Metro Martin Place

Sydney Metro and Over Station Development Design Review Panels

DRP #06

7 August 2018

Updated proposal - S/E and S/W focus

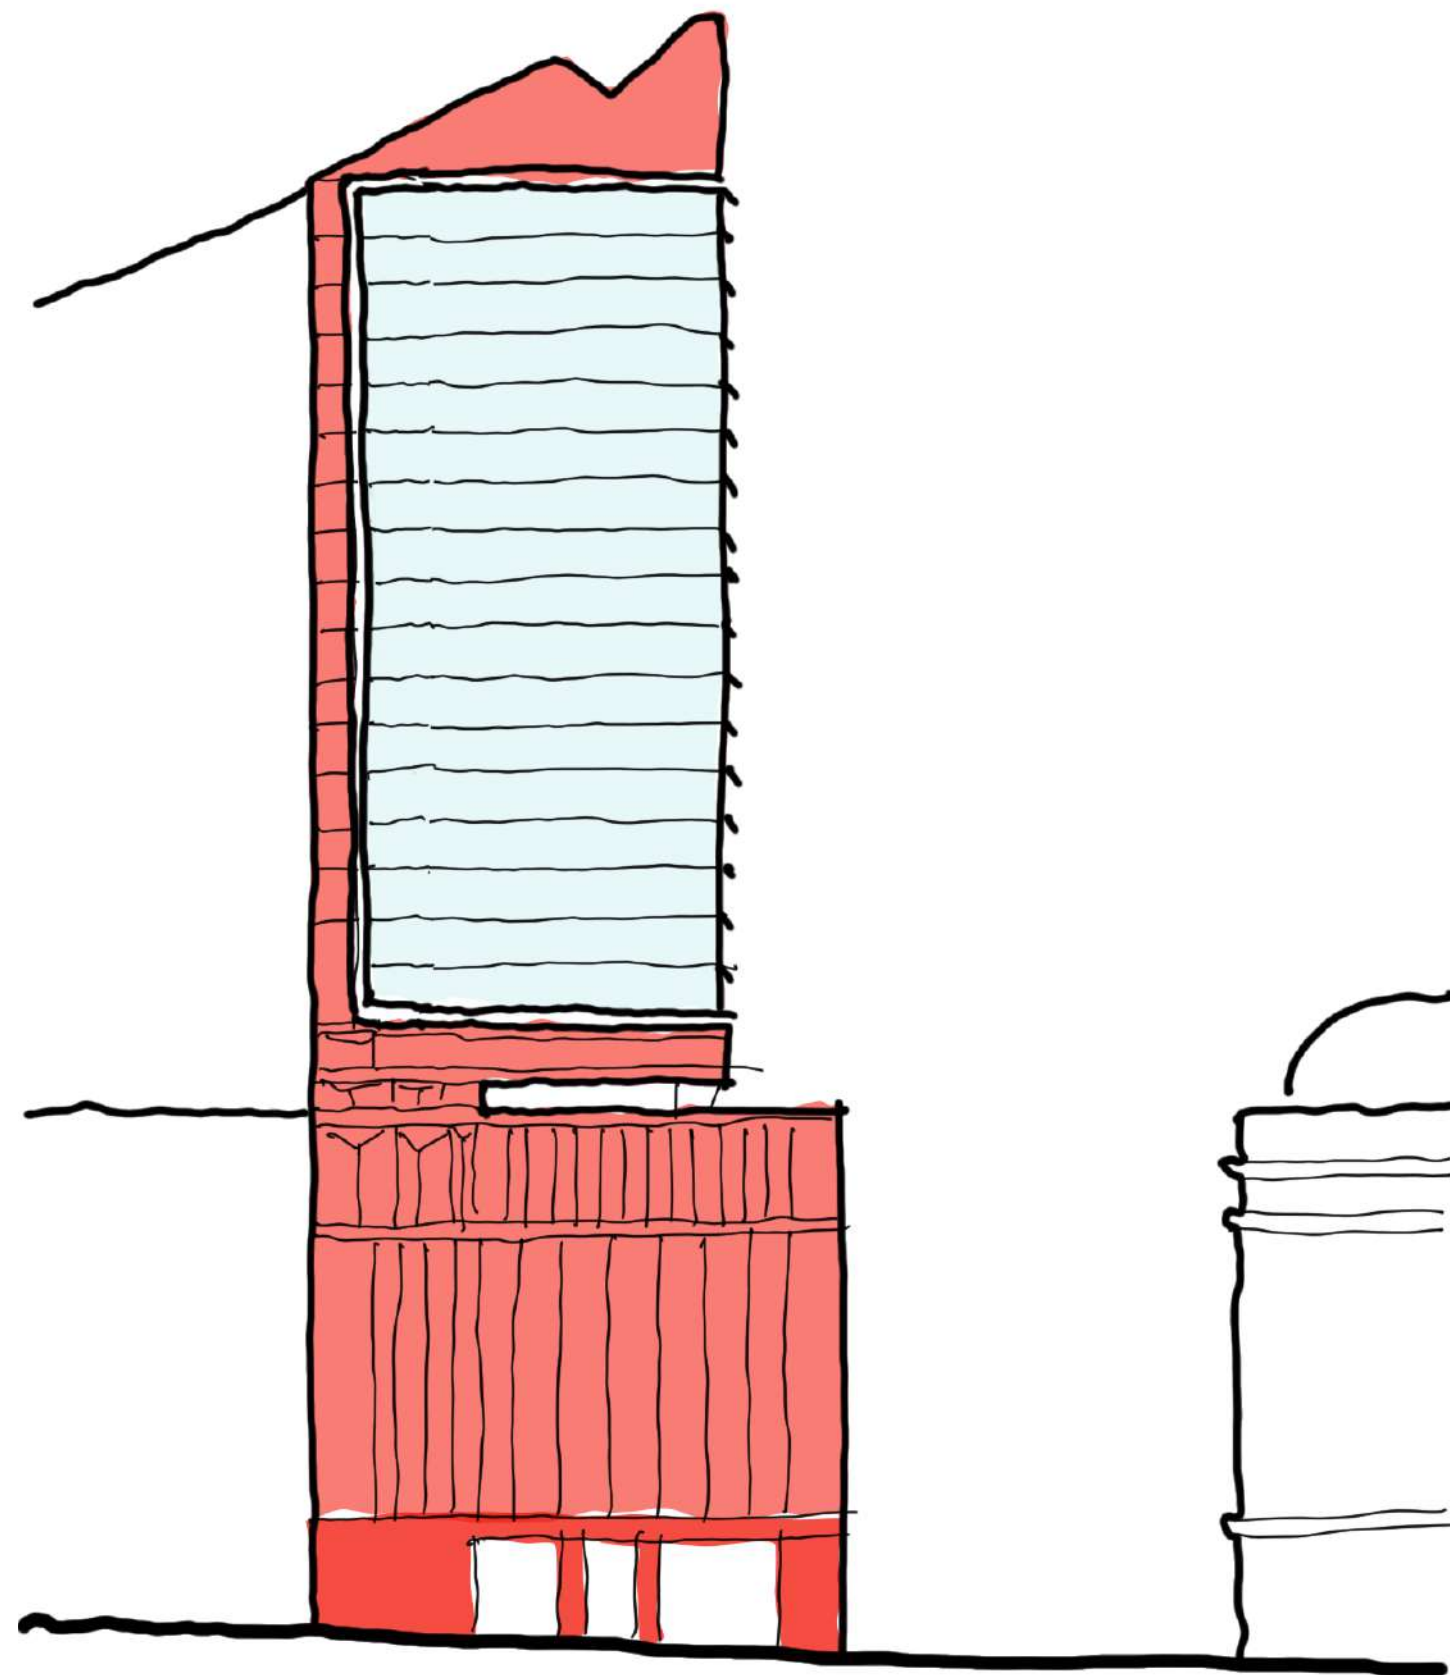
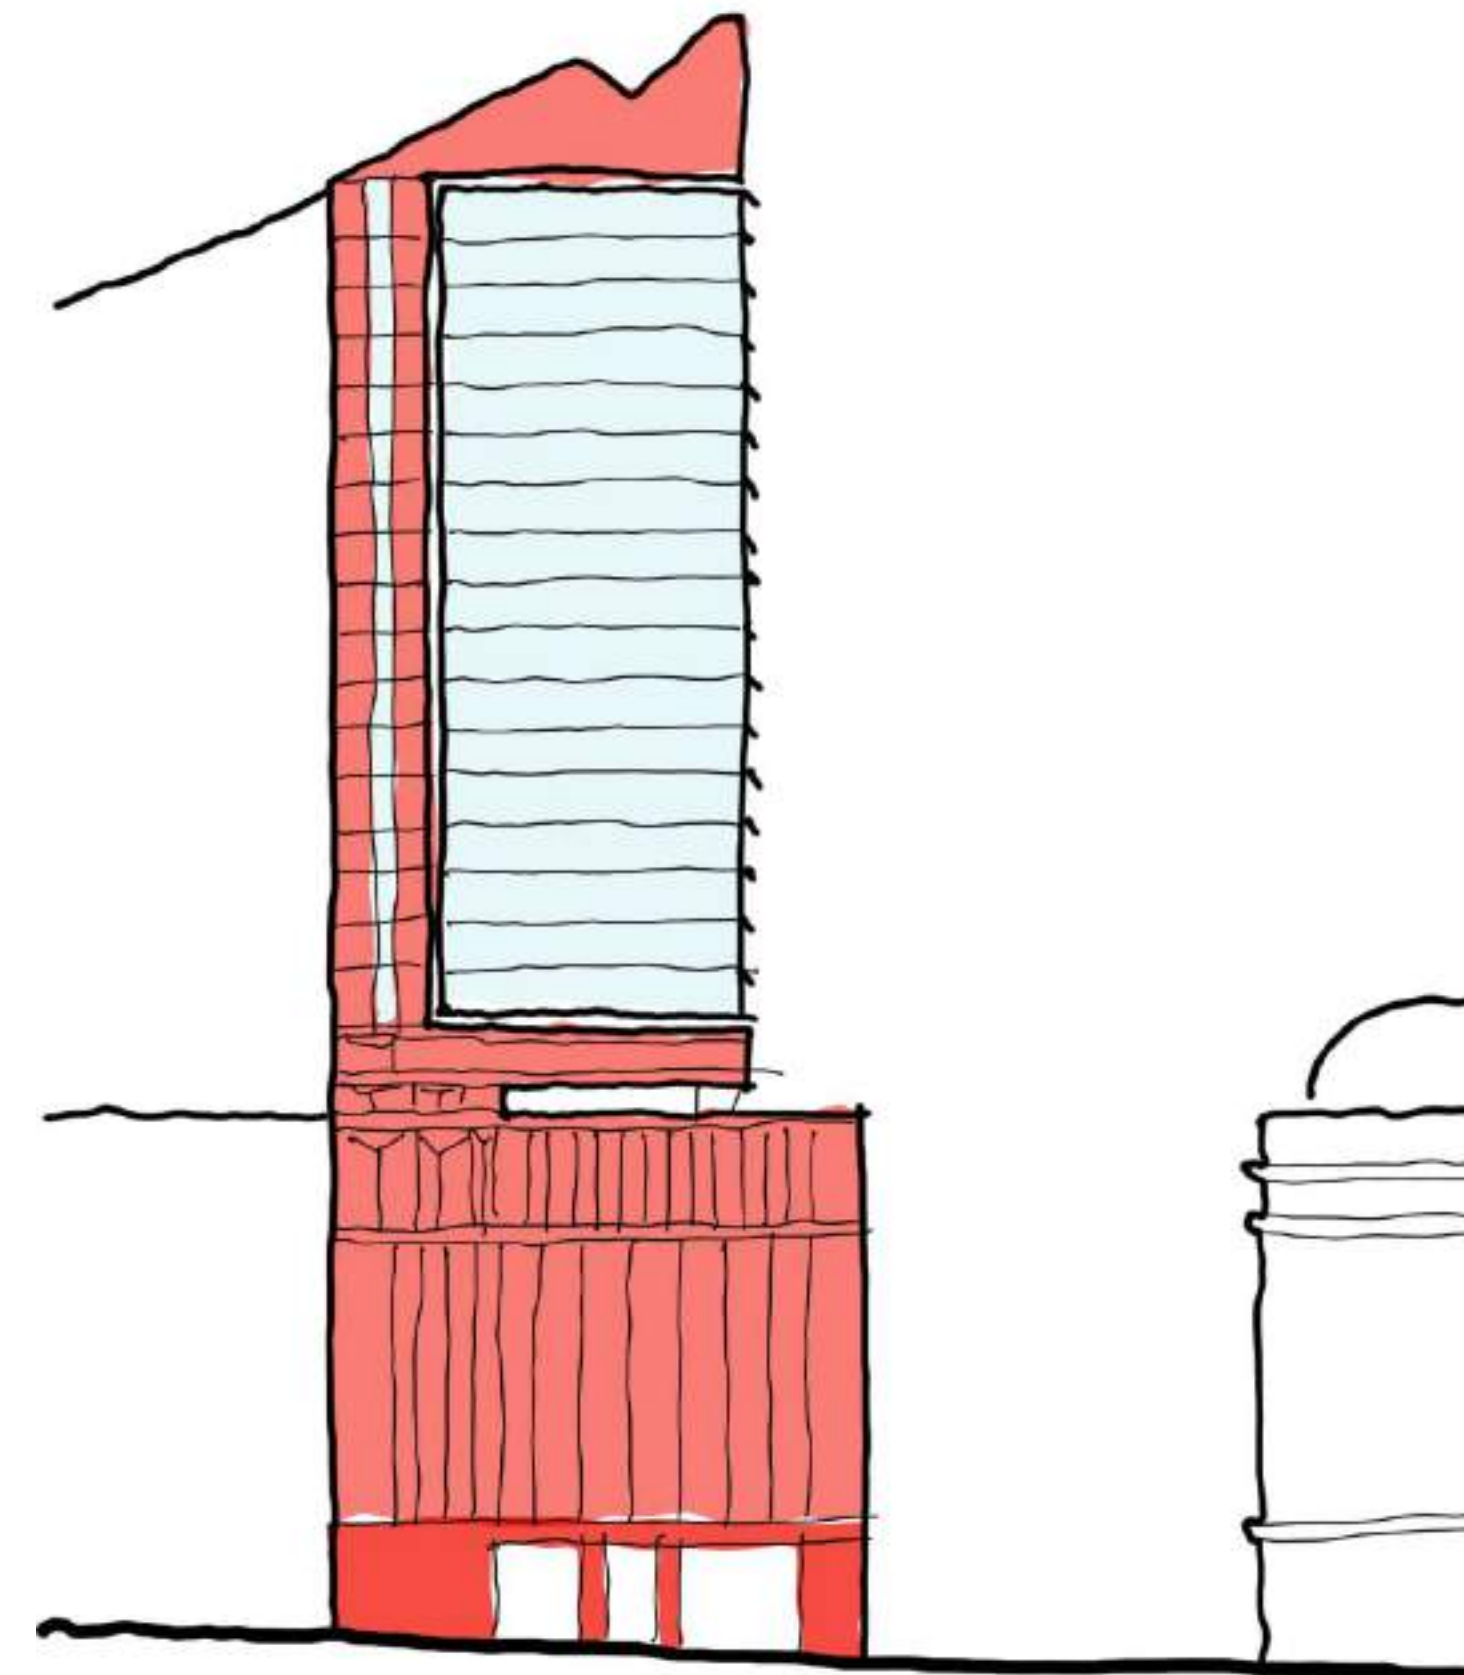
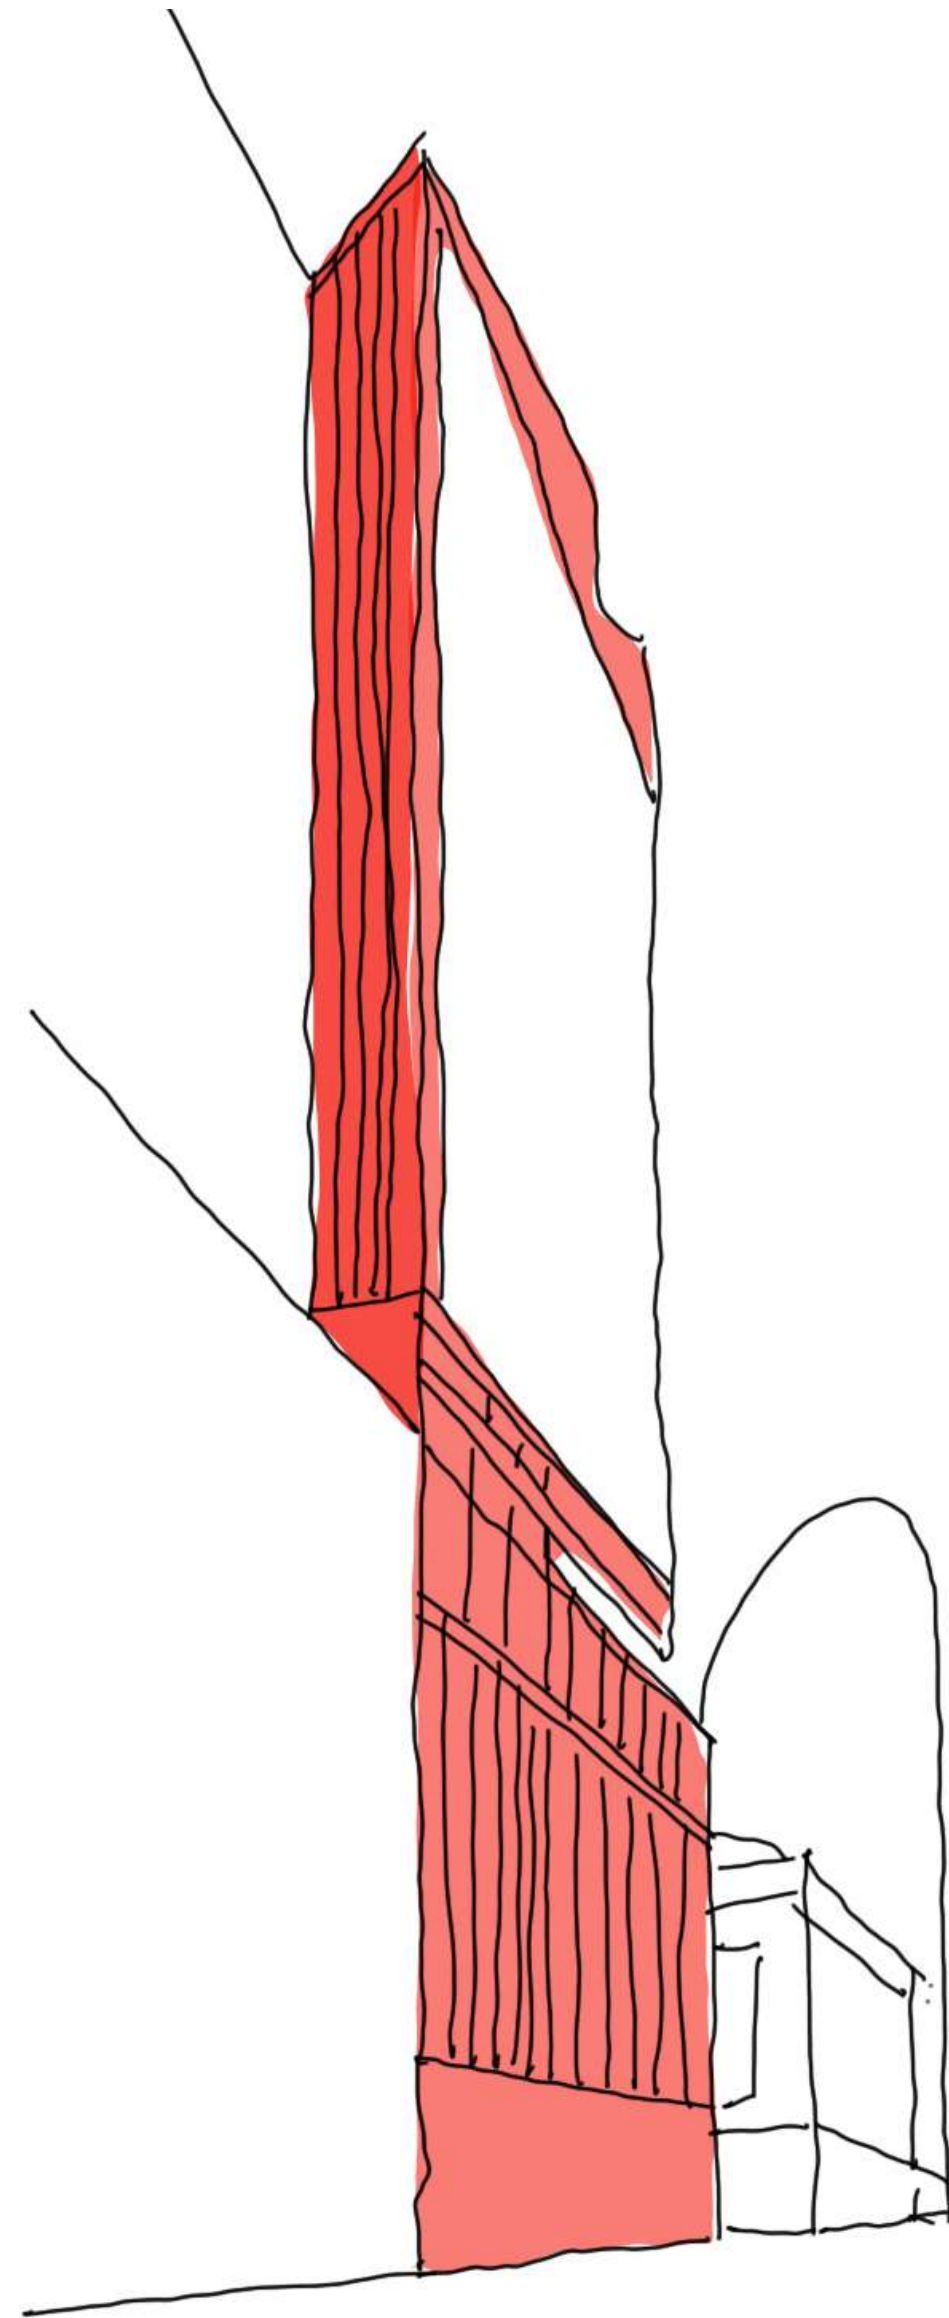
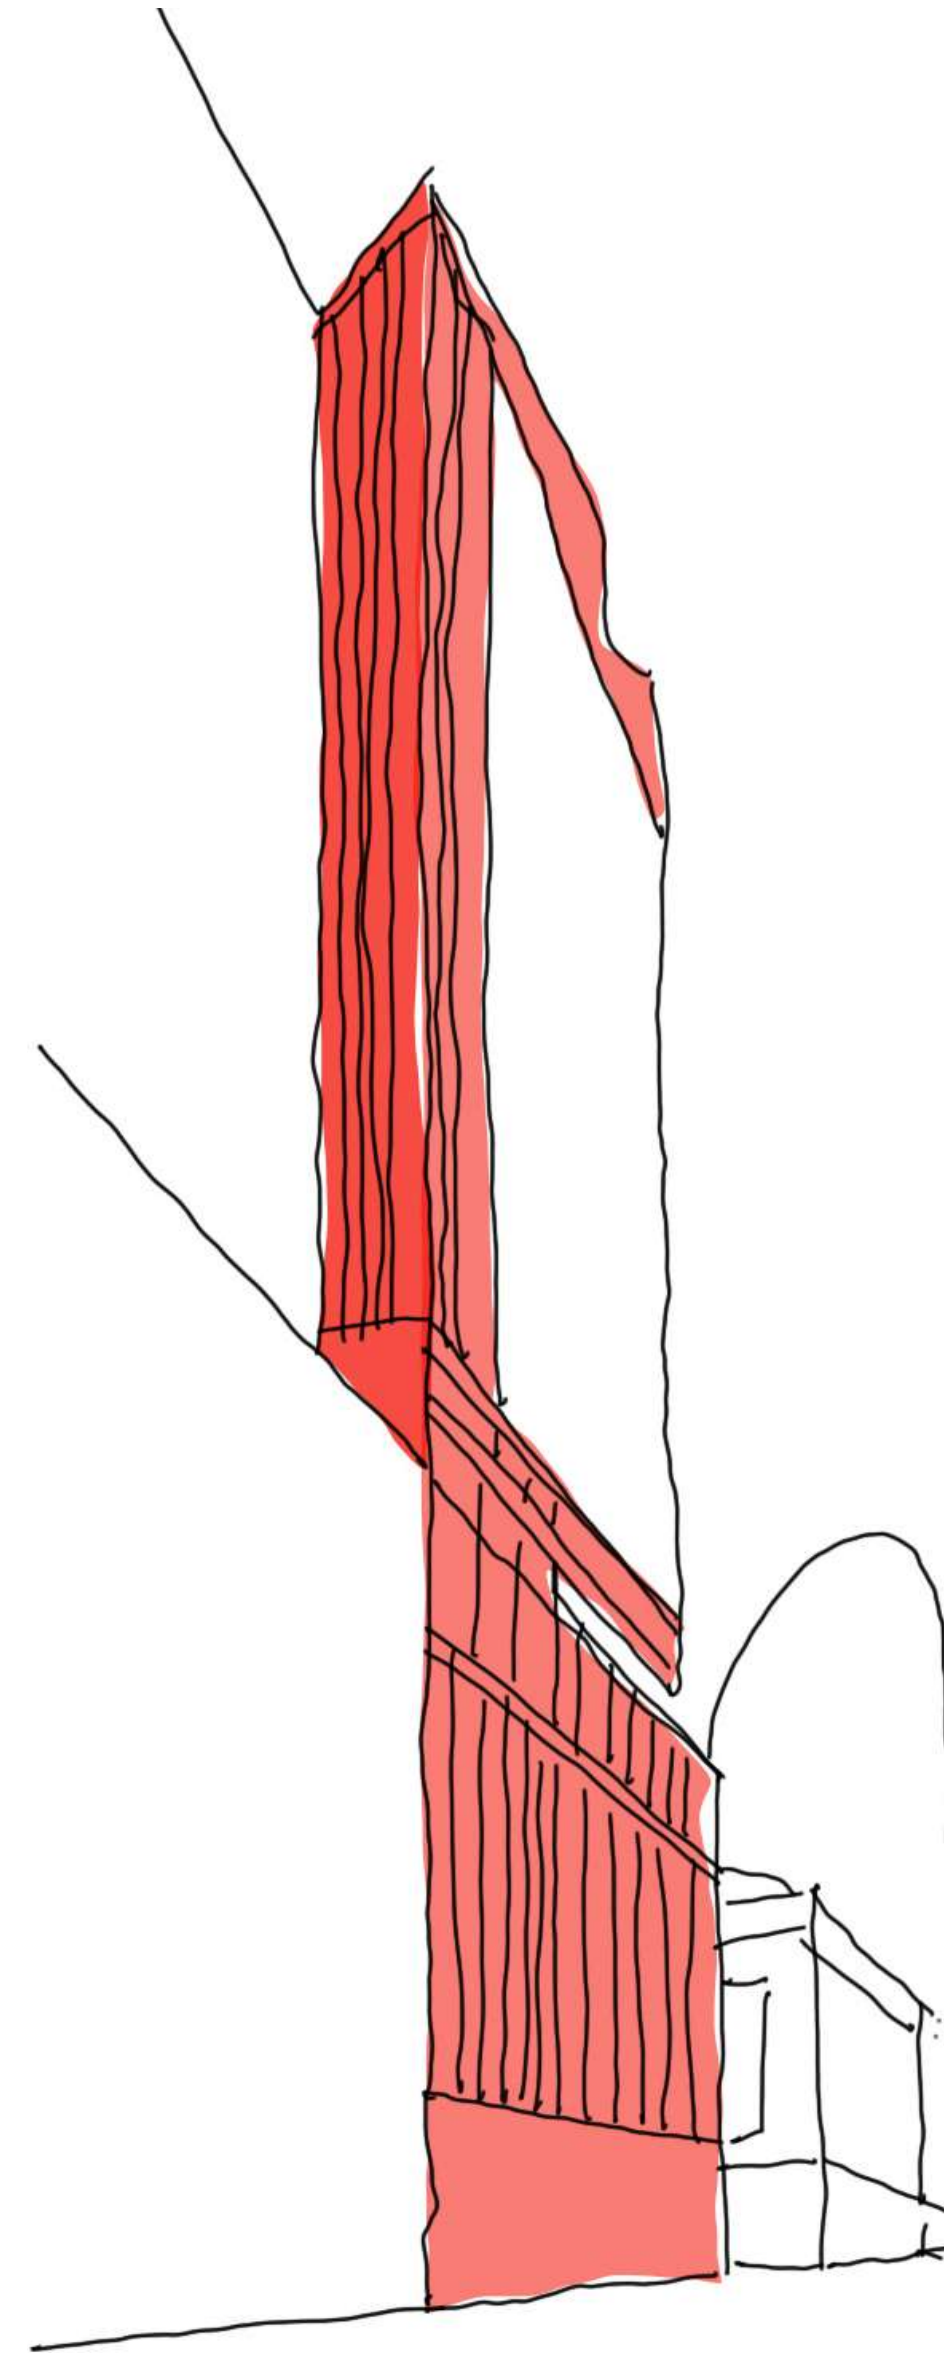
The OSD DRP has indicated the intent of the setbacks above the podium has not been met by the tower and has recommended increasing the setbacks at the south east and south west corners '*to improve architectural expression and urban design outcomes for the block*'.

- the intent of the setback above the podium has not been met by the tower, which extends the full height and width of the approved envelope and is likely to result in a poor urban design outcome for the southern end of the street block and adjacent development
- we recommend increasing the setbacks at the south east and south west corners of the tower to improve architectural expression and urban design outcomes for the block.’

Tzannes presentation, provided under separate cover, responds to the OSD DRP's feedback.
